Rezoning Transportation Analysis
Petition Number: Insert Zoning Petition #2021-012
General Location Identifier: Tax ID 10304112

Revision Log:	Date	Description
	02-25-21	First Review (WB)

SCHEMATIC
SITE PLAN
SCALE: 1" = 30'

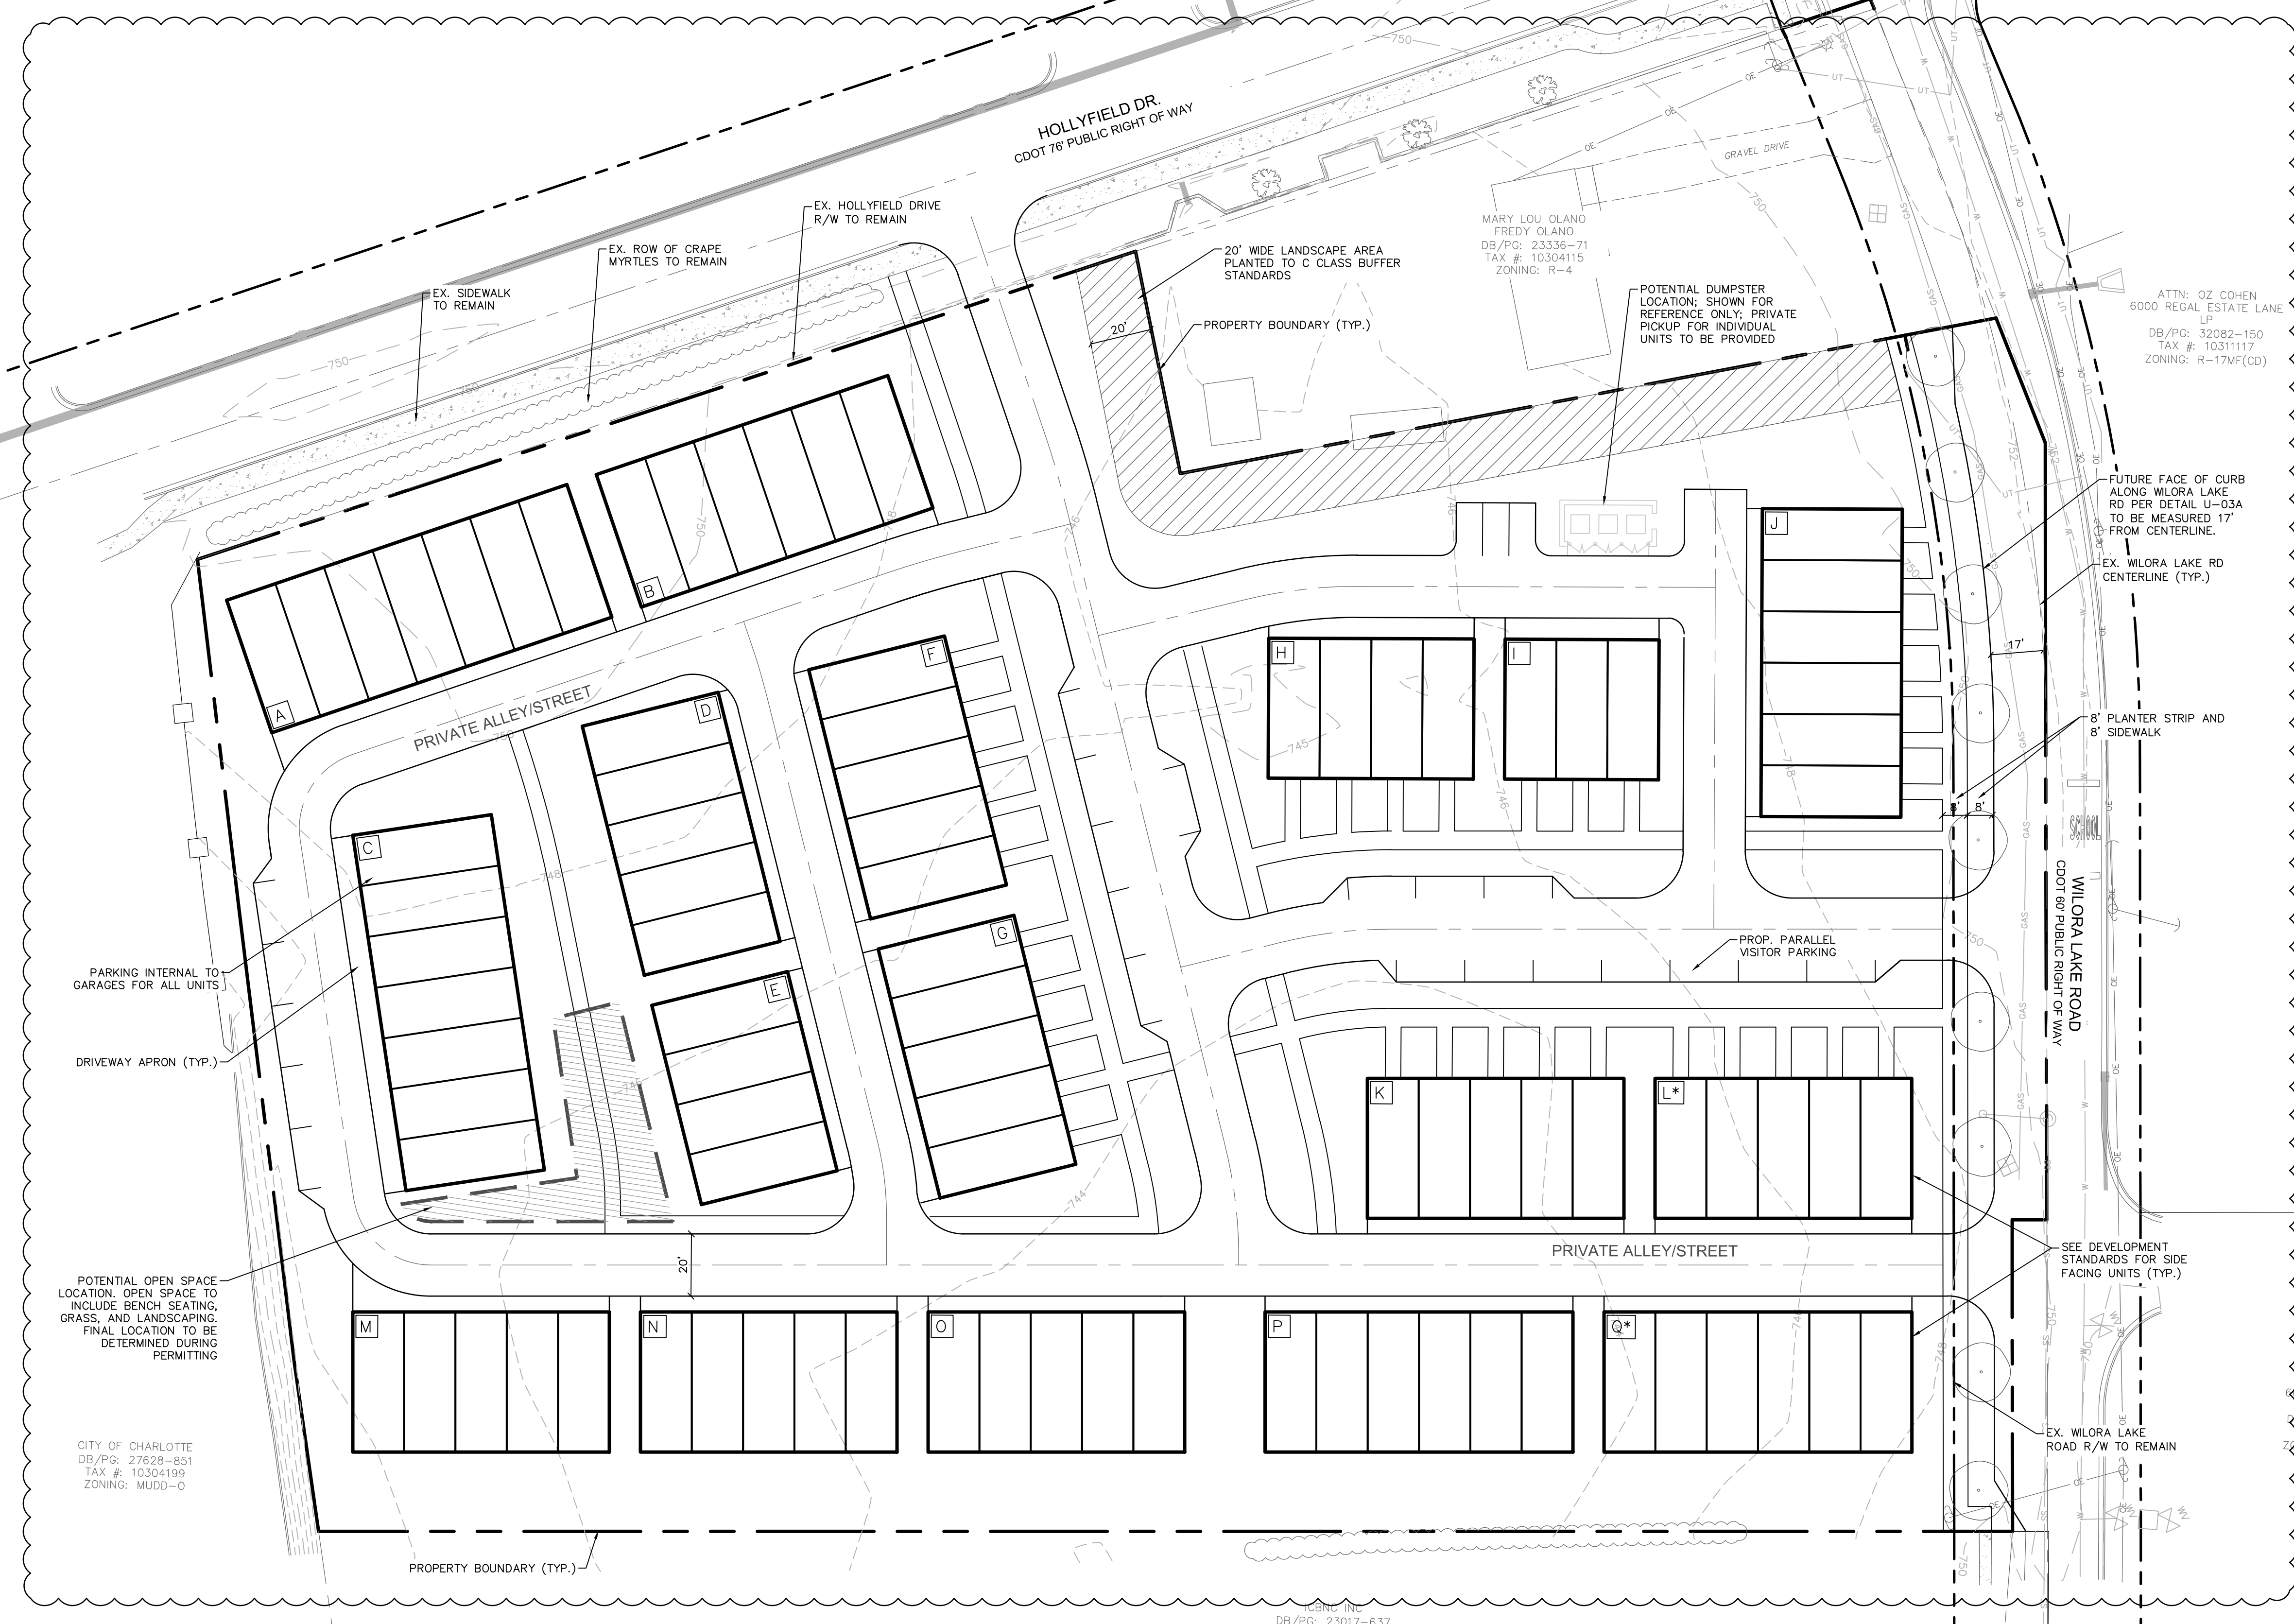
1. **Curblines:** The proposed zoning district has a setback measured from back of the existing or proposed future curblines.
 - a. **Wilora Lake Road:** The curb and gutter needs to be at 17.5 feet from the Wilora Lake Road centerline.

Label and dimension the back of curb and gutter from the road centerline.

3. The site plan commits to construct an 8-foot planting strip, 8-foot sidewalk along the site's Wilora Lake Road frontage leaving a sidewalk gap of less than 100' north of the site. Revise site plan and conditional note(s) to commit to extend the proposed 8-foot planting strip and 8-foot sidewalk to the Hollyfield drive intersection and tie into the newly constructed ADA curb ramps to assist CDOT in close a gap in pedestrian infrastructure.

The site plan shall label and dimension both items from the back of curb and gutter.
